From: [NectonSubstationAction Messenger](#)
To: [Norfolk Boreas](#)
Subject: Deadline 7
Date: 07 March 2020 18:21:36

In answer to Colin King's questions regarding the accuracy of the photomontages and other simulations provided by the applicant, they answer

Title:	Scenario 2 Viewpoint 9: St Andrews Lane, Necton
--------	---

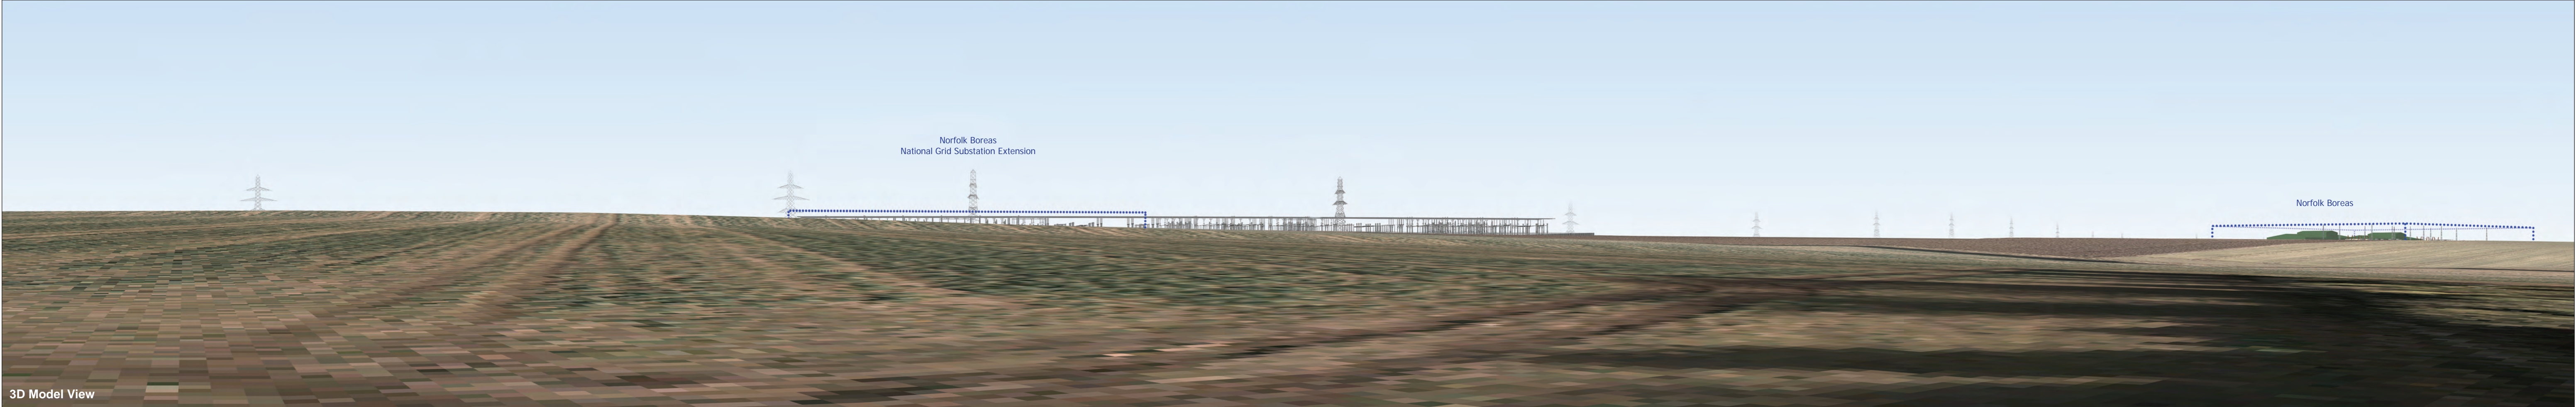
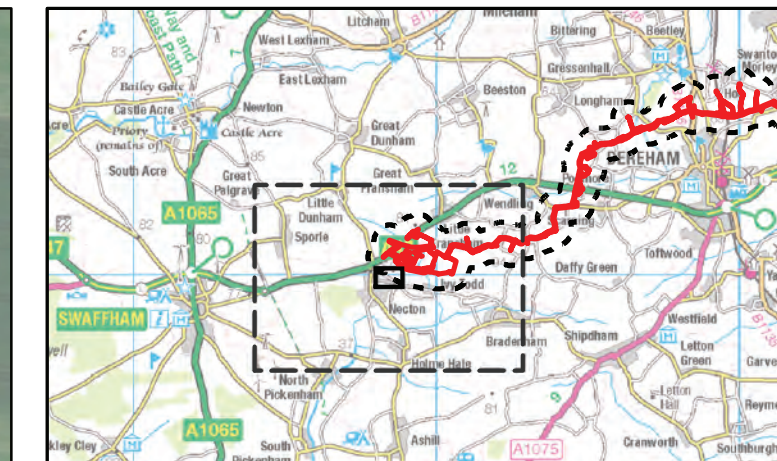
Any inaccuracies that do occur in Terrain 5 DTM will not affect the height of the substation as shown in the models or the photomontages. This is because the existing landform is not used as the base for the substation, but instead a new flat floor plain for construction is applied, which replaces the Terrain 5 DTM over that area.

1. This is exactly what worries us. If the terrain is not flat but undulating (which it is), will the applicant level downwards or upwards? If part of the site were for instance to have an existing ground level of 72m and another part lower, which height will they level to? If they bring in soil and level to the higher point, then even more mitigation (and we seem to be getting less instead) will be needed. The common sense approach would be to level down and use the soil to create the bunds we keep asking for?

2. The applicant seems quite happy to admit that they have committed inaccuracies, and it is surely not too much to ask that with the completely monstrous and ghastly structures they wish to dump upon us, we see exactly what the results will be.
